RE: Responses to Pre-Application Comments  
White Barn Brown Bear Carwash  
8833 Soper Hill Road, Marysville, Washington  
City File No. 23005  
Our Job No. 22681

## **Pre-Application Conference – Response to Comments**

01 TRASH ENCLOSURE - PLAN

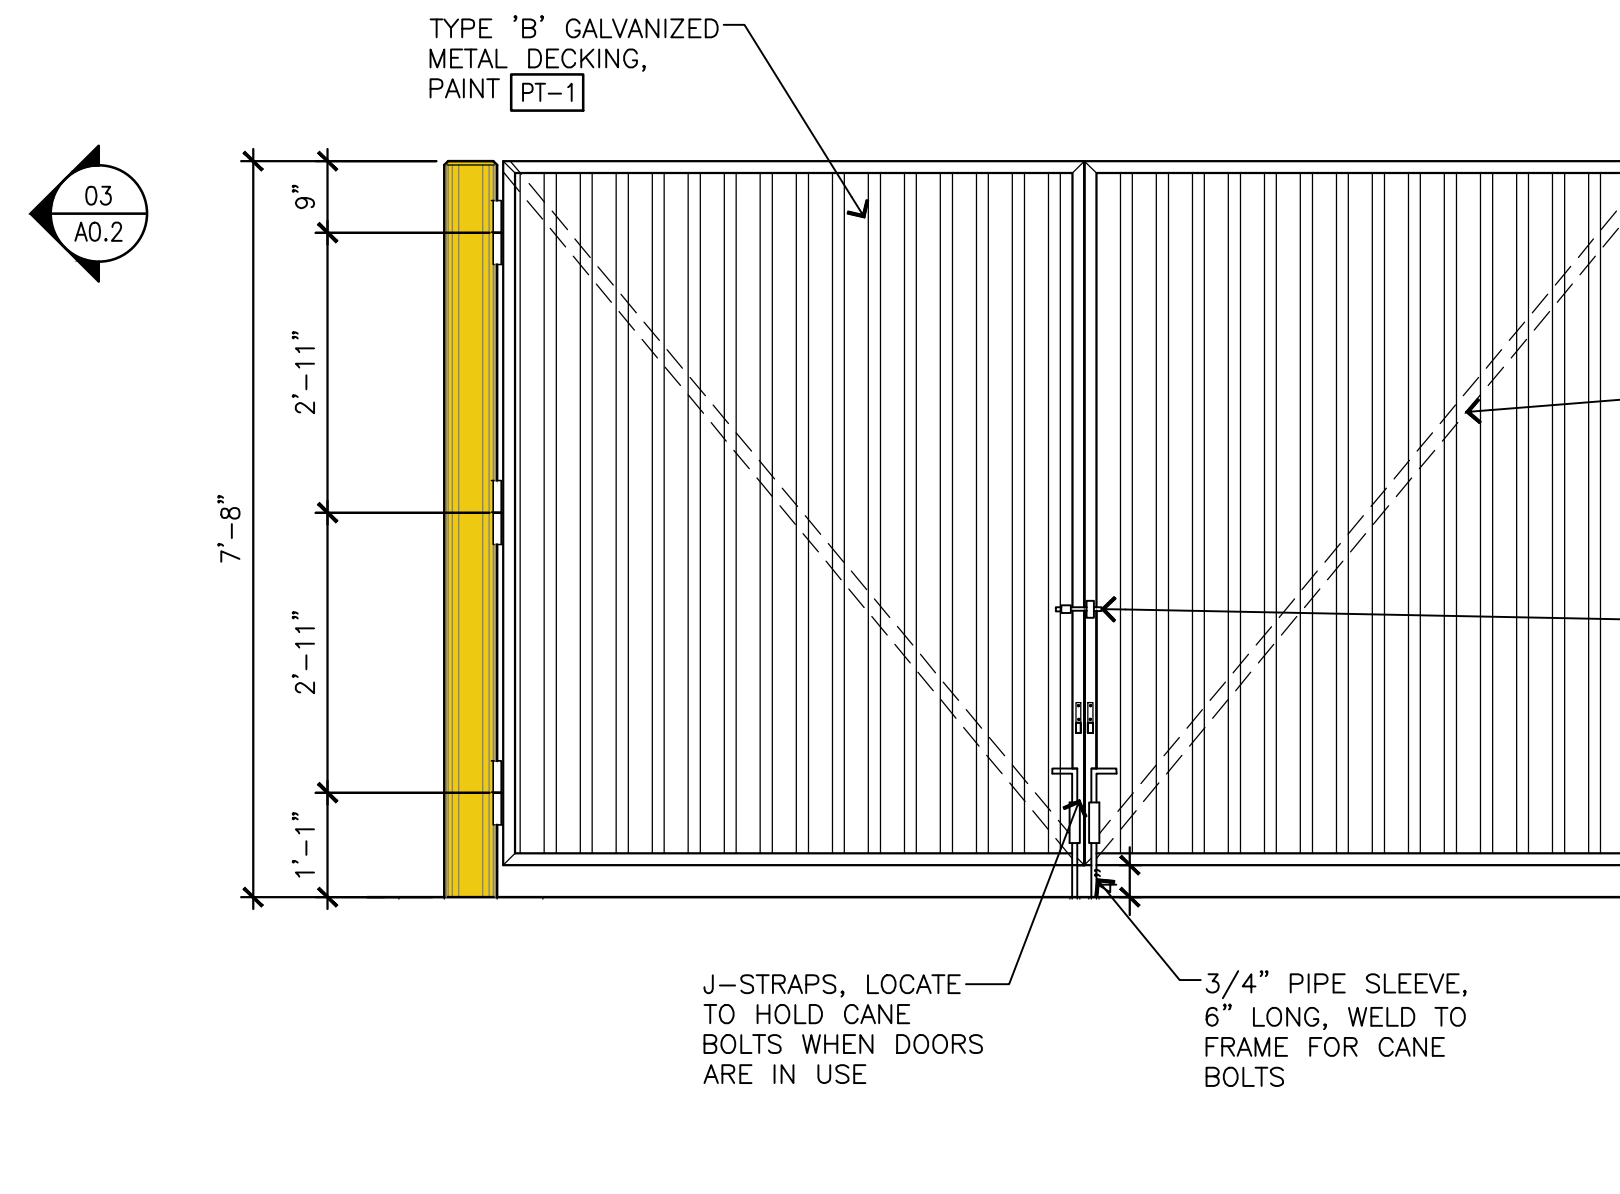
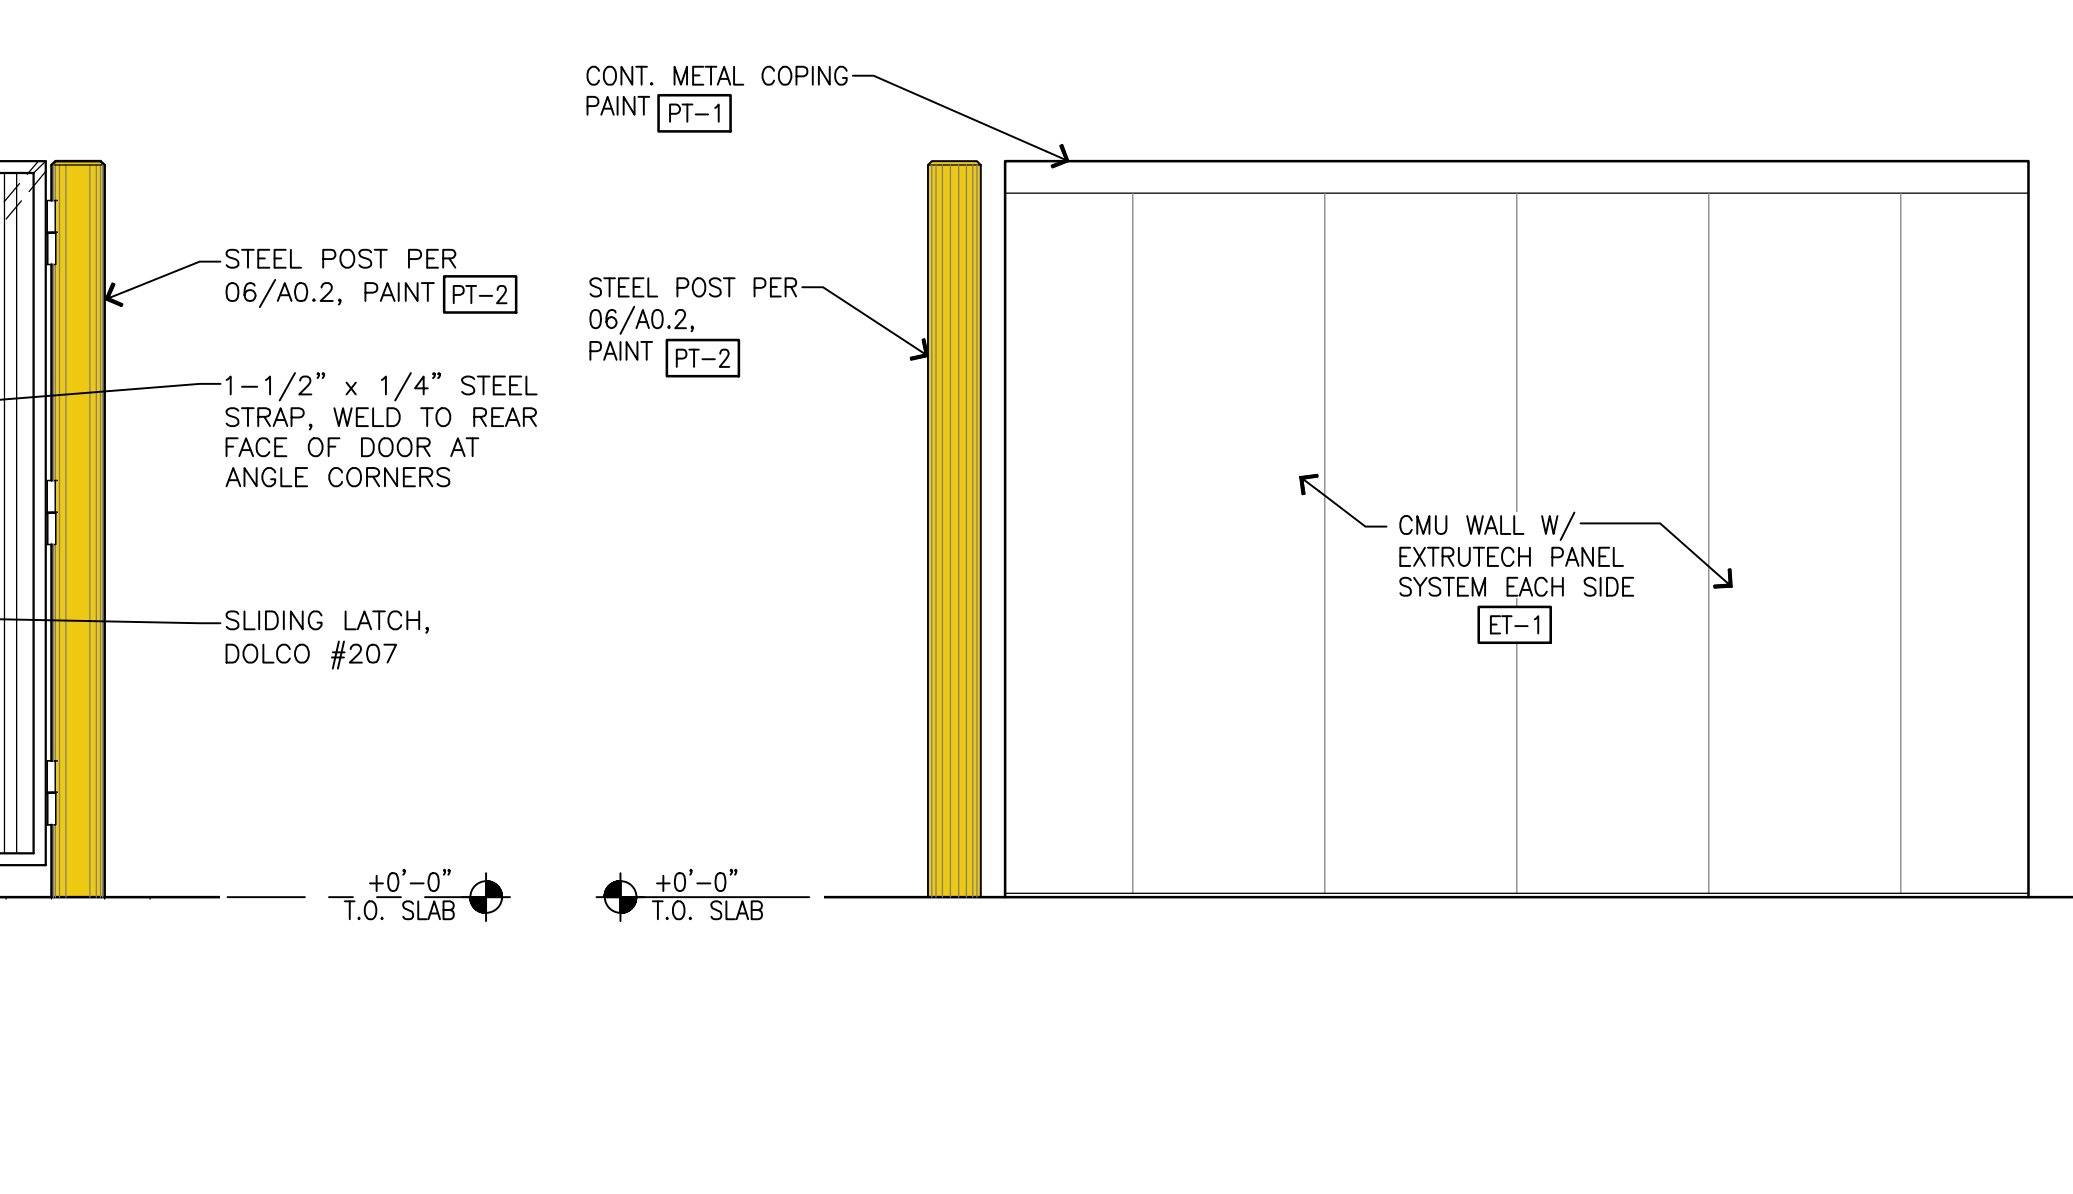
- l. Refuse containers shall be screened with a six-foot masonry wall on three sides.*

**Response:** Provided. Please see sheet A0.2 for trash enclosure elevations.

**BROWN BEAR CAR WASH**

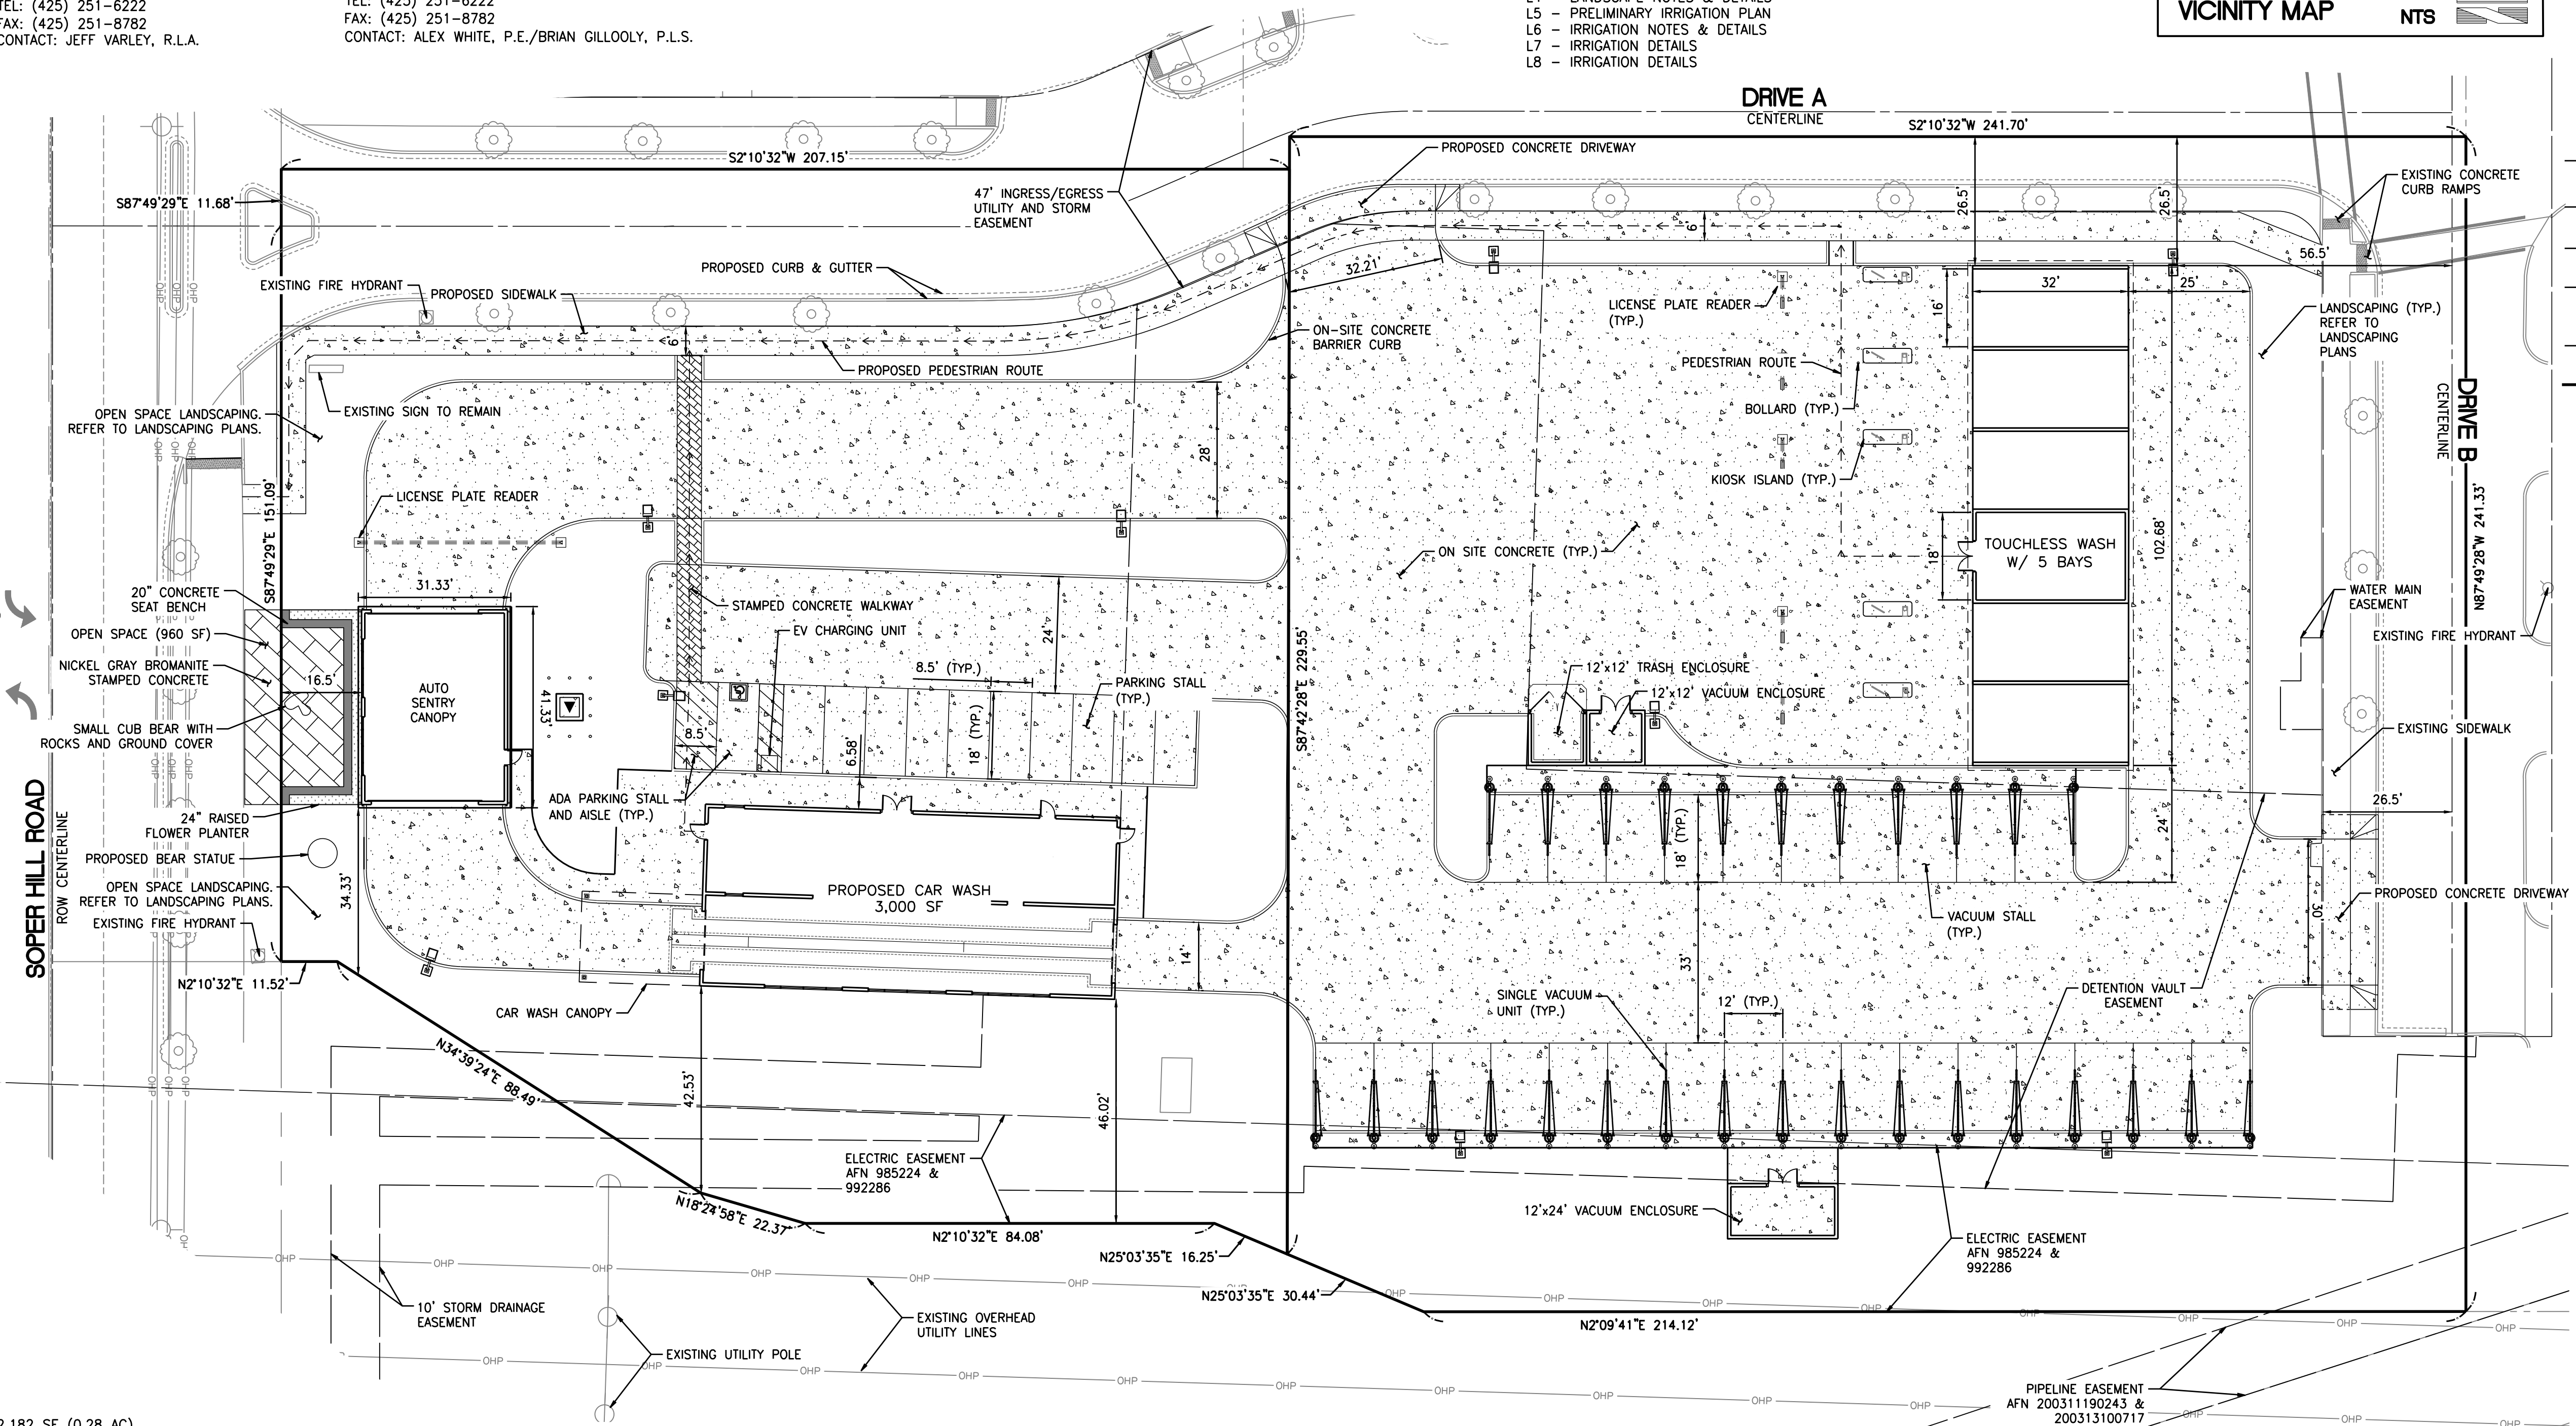
- h. Vehicular and pedestrian cross-access should be provided with adjacent commercial properties.*

**Response:** Provided. Please see sheet C1.0 for driveway and sidewalk locations.
